Date: January 10, 2018
To: Jenna and Matthew Arvidson
2310 Wakonda Way
Monument, Colorado 80132
From: Logan L. Langford - Geologist *LLL*
Project: Entech Job # 171248
Soil, Geology, Geologic Hazard, and Wastewater Study
2310 Wakonda Way
Monument, Colorado
Re: EPC Report Redlines

**SOIL, GEOLOGY, GEOLOGIC HAZARD,
AND WASTEWATER STUDY
ARVIDSON SUBDIVISION
2310 WAKONDA WAY
MONUMENT, COLORADO**

Project No.
MS-17-006

FIG NO.:
5

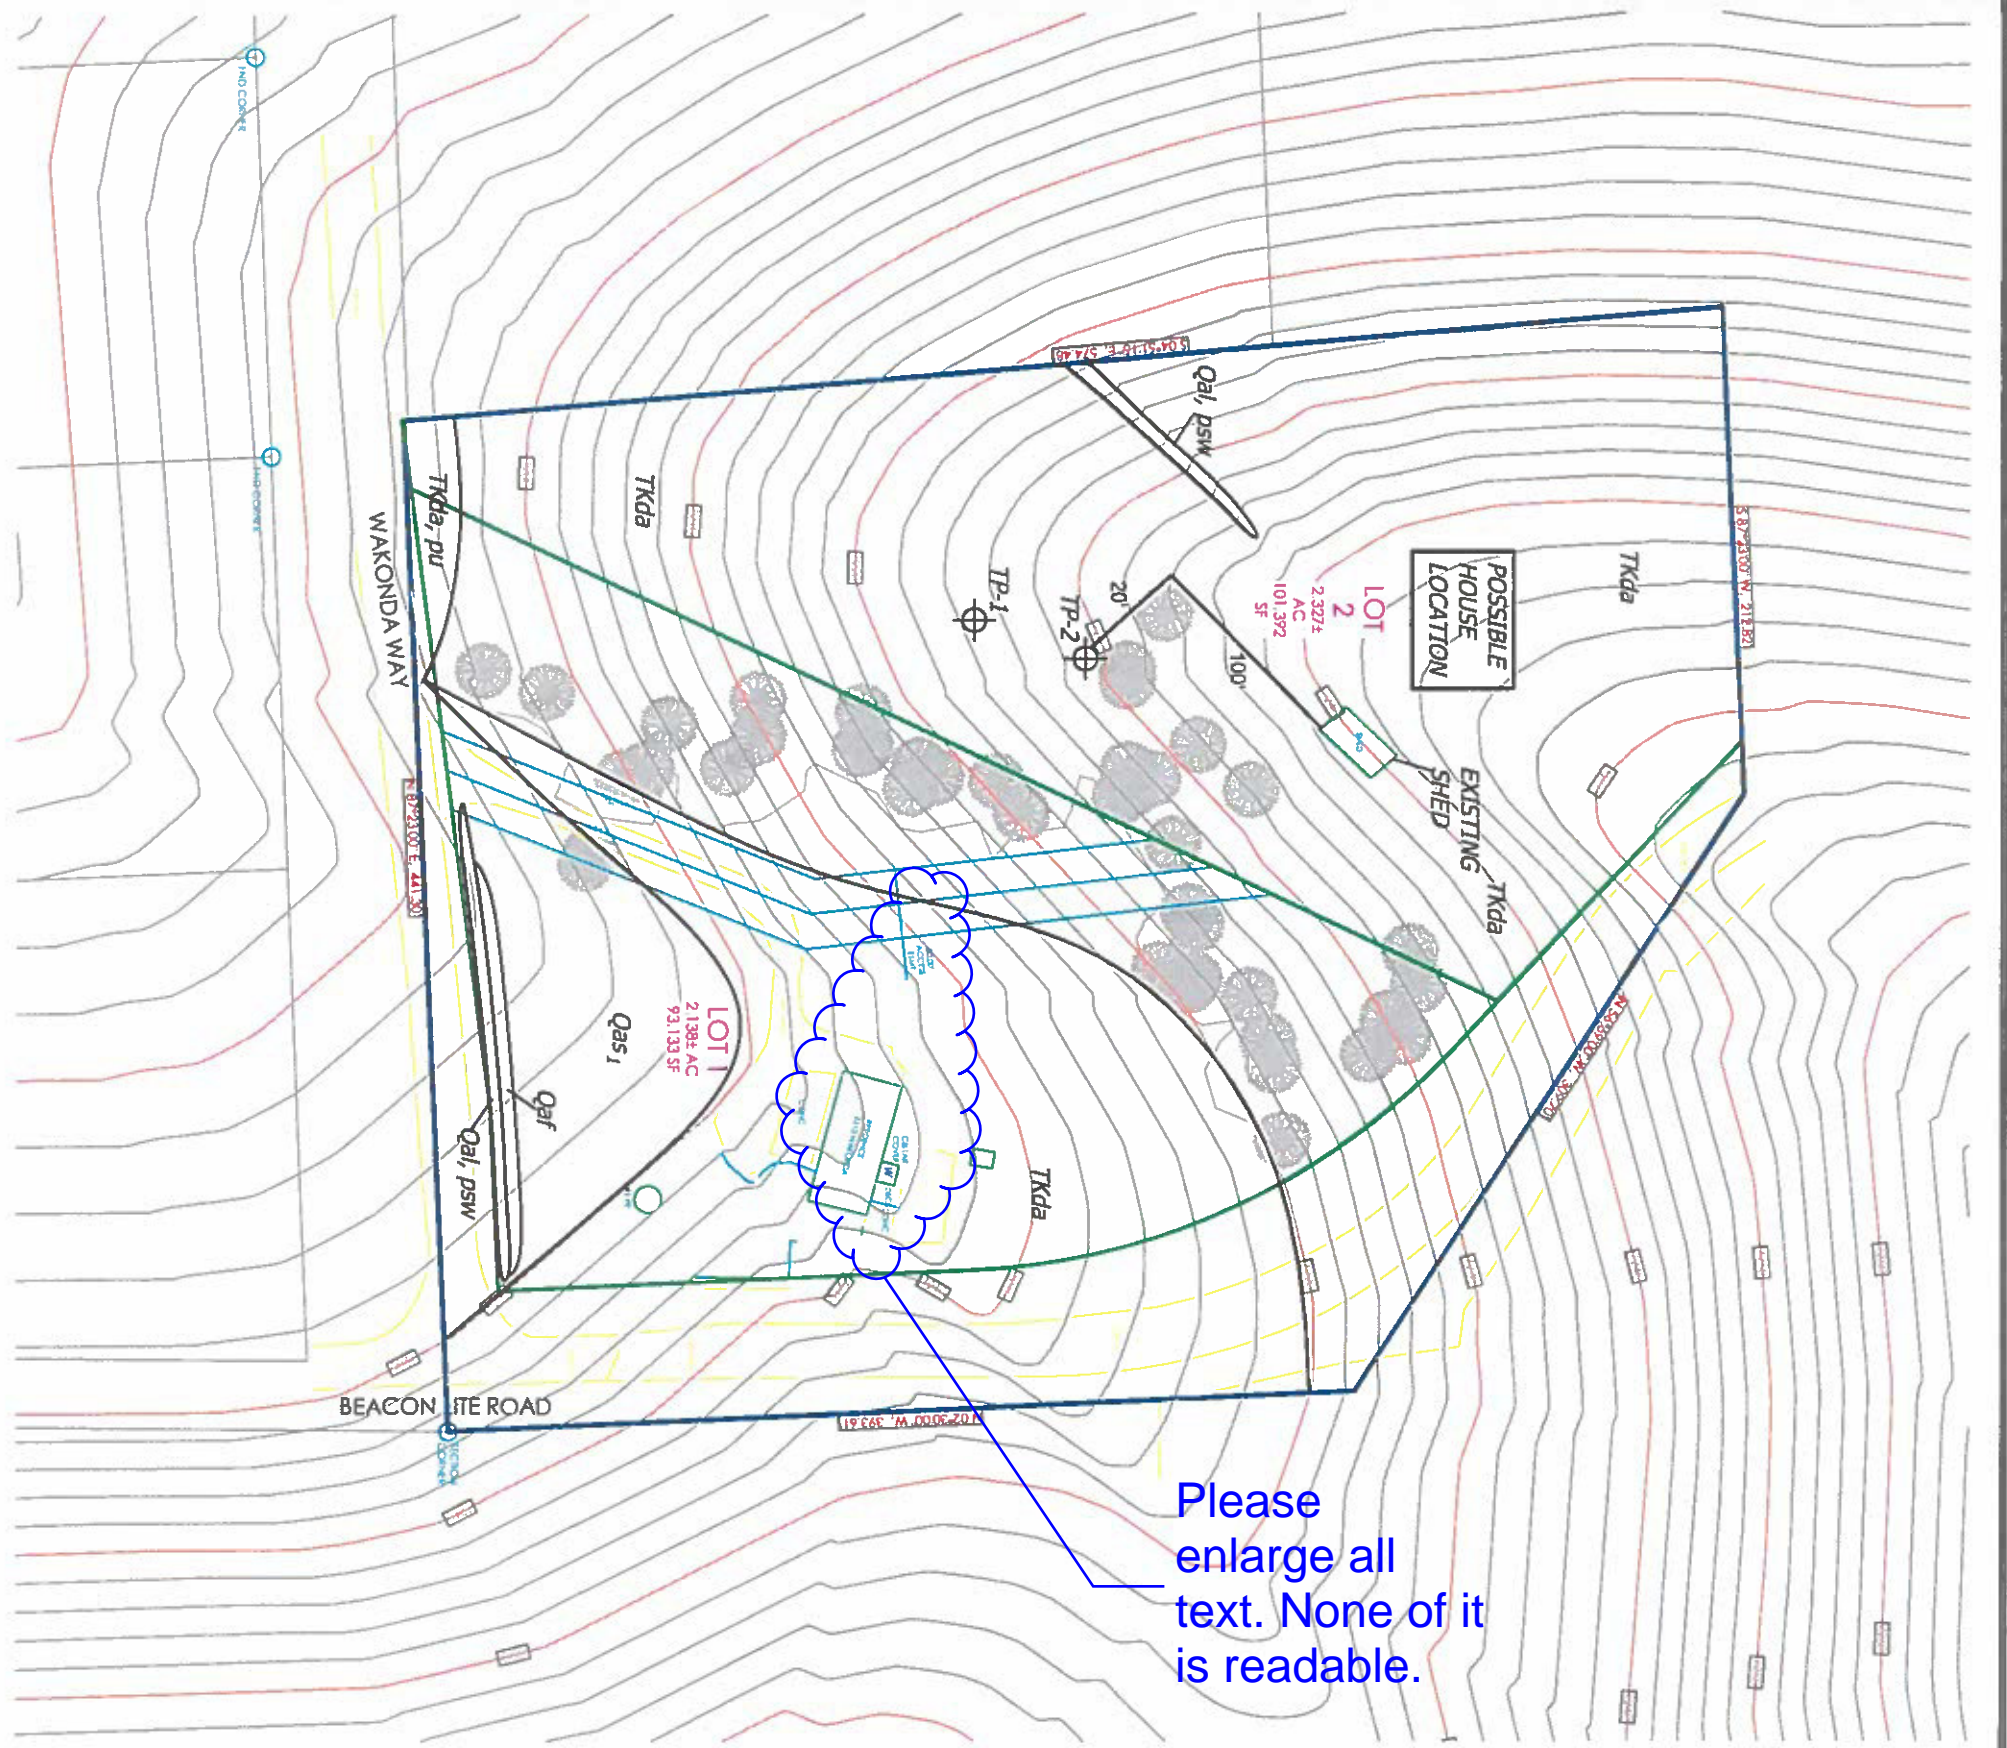
what exhibit
are these
areas shown?

Please call out
on exhibit and
call out which
exhibit in this
paragraph.

Geologic hazards present on the site are indicated on the Geology/Engineering Geology Map. See legend for descriptions. Hazards present on the consist of potentially unstable slopes (indicated on the map as pu) and potentially seasonal shallow groundwater area (indicated on the map as psw).
